Application No: M/21/21/HH
Site Address: 34 Sea Lane Middleton-On-Sea PO22 7RT
Description of works: Single storey rear extension and loft conversion.

Thank you for your internet representation made on 19th March 2021 which has been recorded as an objection with the comments as follows:

DRAWING
PROPOSED
ELEVATIONS
DRAWING No
335/07
REVISION
SCALE 1:100
DATE FEB 2021
DRAWN LA
CHECKED

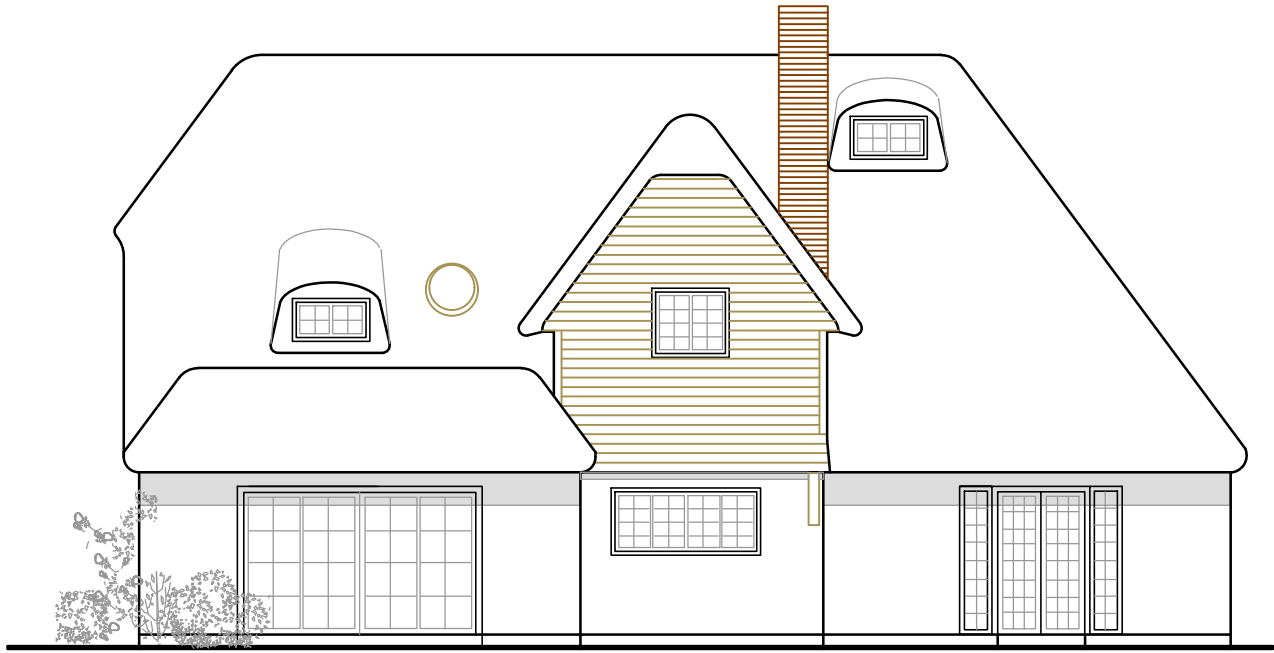
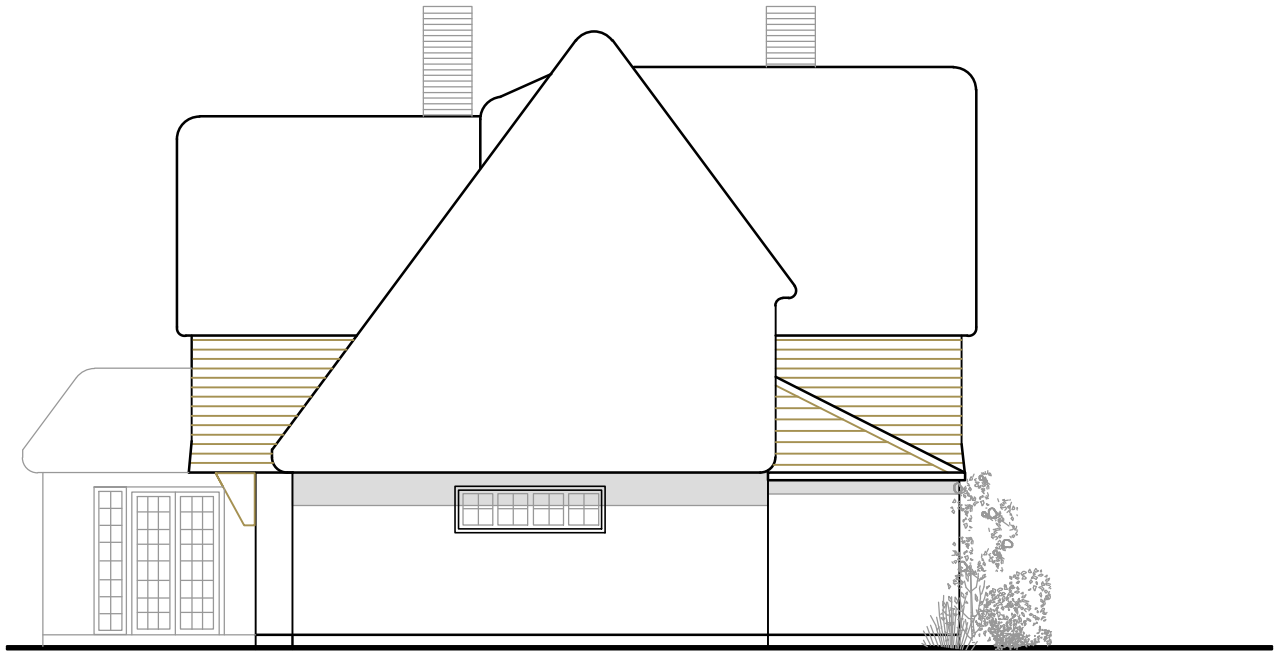
Members agreed to object to this planning application on the following issues,
Proposed development will impinge on the privacy of the adjoining property
It does not meet the requirements set out in the Village Design Statement.
This is in an Area of Special Character and the design needs to reflect this with regard to thatched roof properties.
